PROJECT MEMO: 23 Ocean Avenue

RE: Response to Preliminary Staff Comments

Draft Subdivision Plat Review William Clark 07.11.2016

A	SITE PLAN PERMITTING	6-6-16
No.	Revision/Issue	Date
Design by:	JIM	Checked by: SJB
Drawn by:	JIM	Approved by: SJB
Project:	161.06035	
Sheet No:	C1

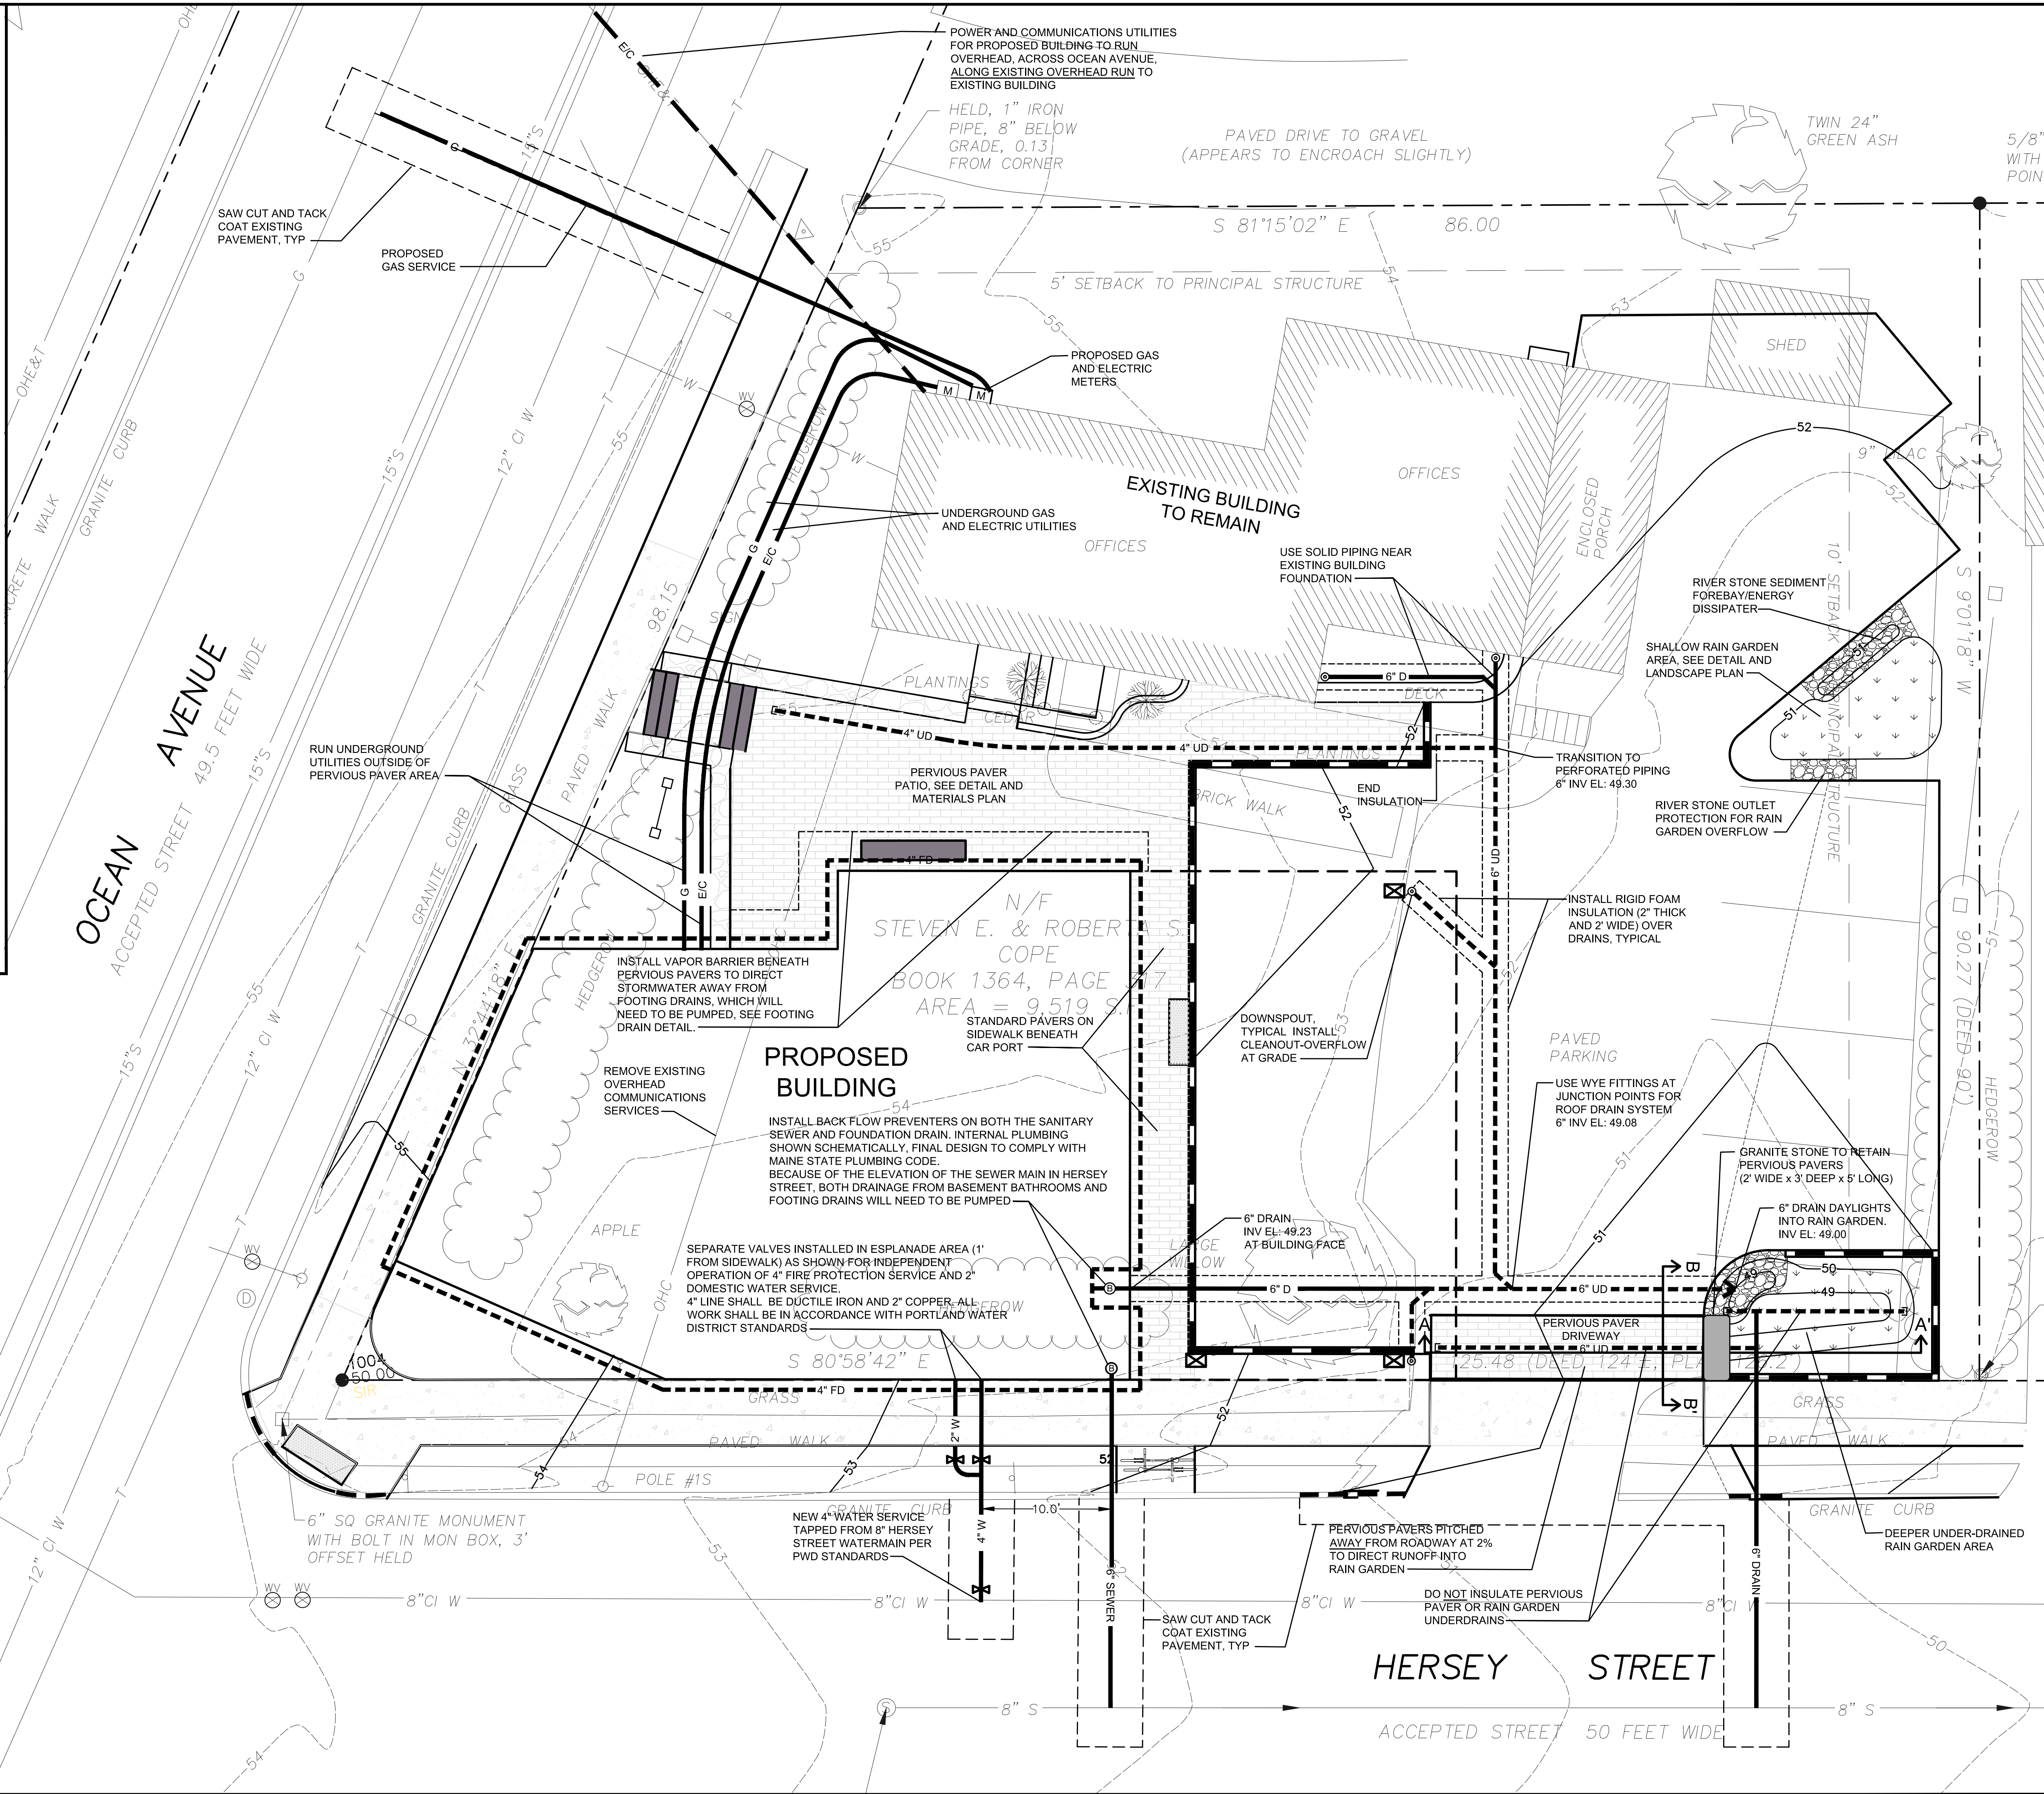
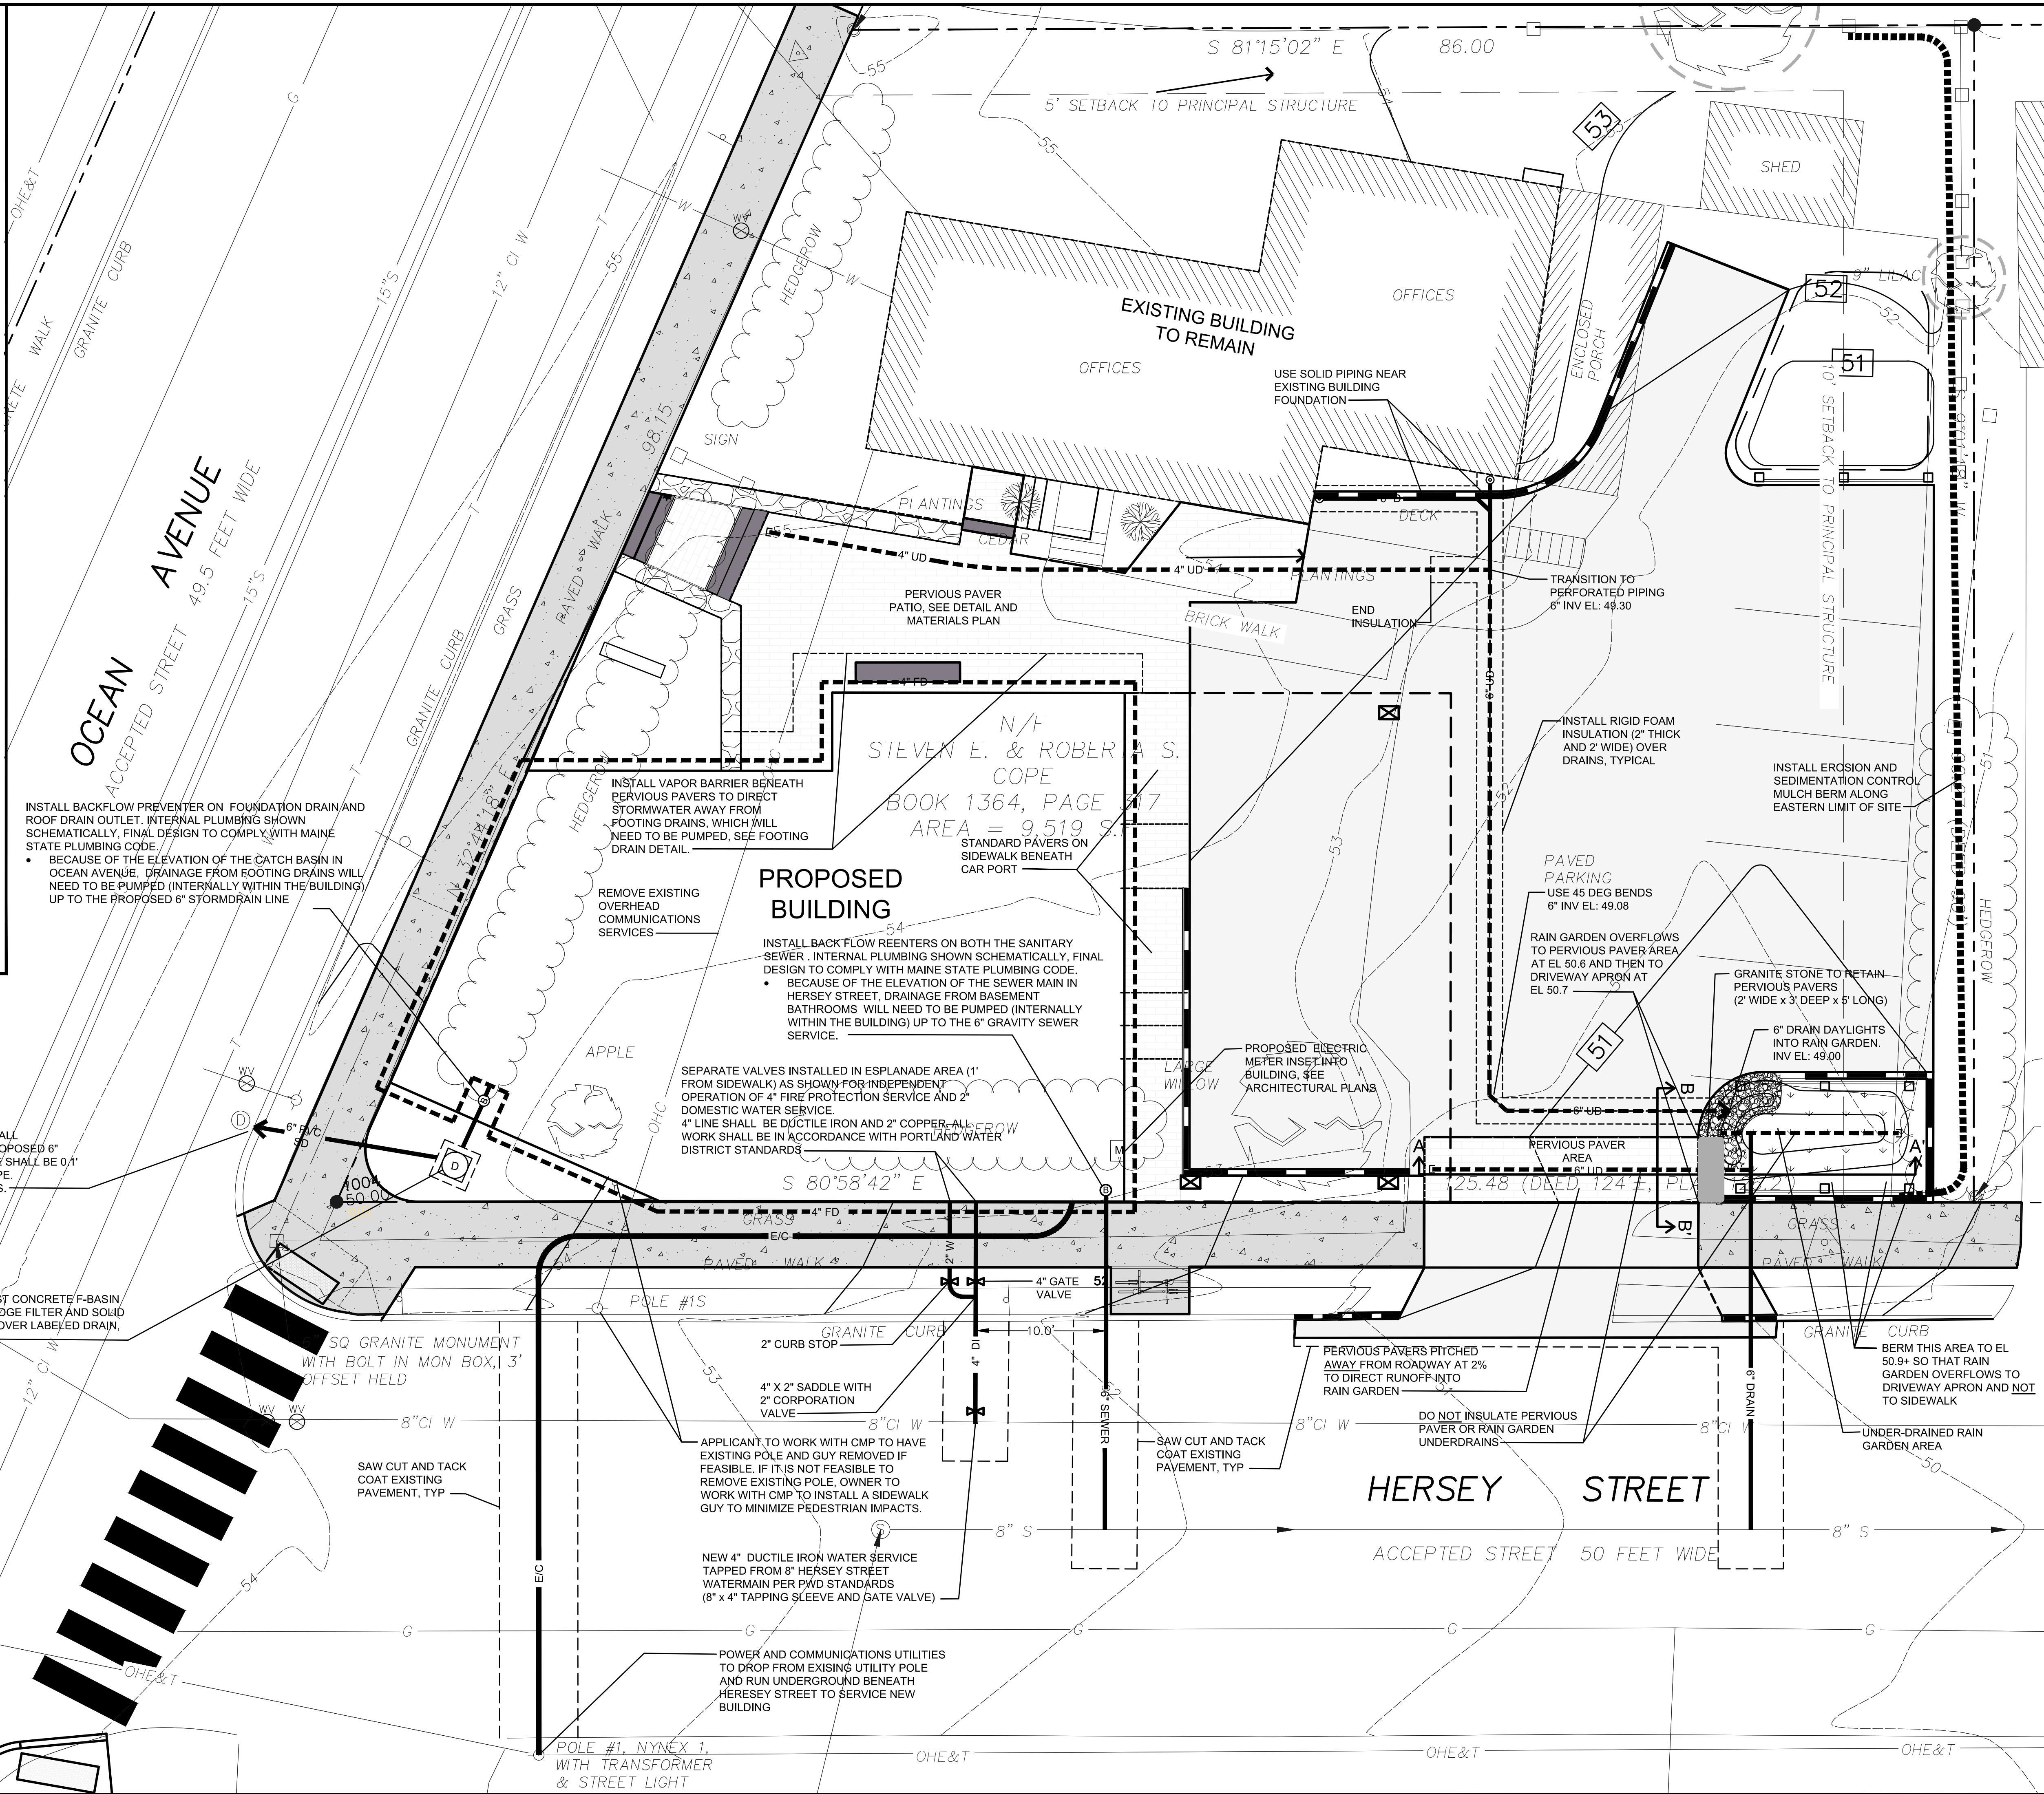
Comment #6. Overhead electric is not permitted. Please confirm a plan for underground electrical with CMP and revise plans accordingly. Can the existing pole on Hersey Street be removed?

Response: The utility plan has been revised to provide underground electrical service from Hersey Street. Owner will work with utilities to remove the existing pole adjacent to the new building if feasible. However; it may not be feasible to remove this pole because it appears to be a strain pole intended to offset the pull of the sizeable 3-phase service to the restaurant across Hersey Street. If it is not feasible to remove this pole, owner will work with utilities to install a sidewalk guy to support the pole while minimizing pedestrian impacts.
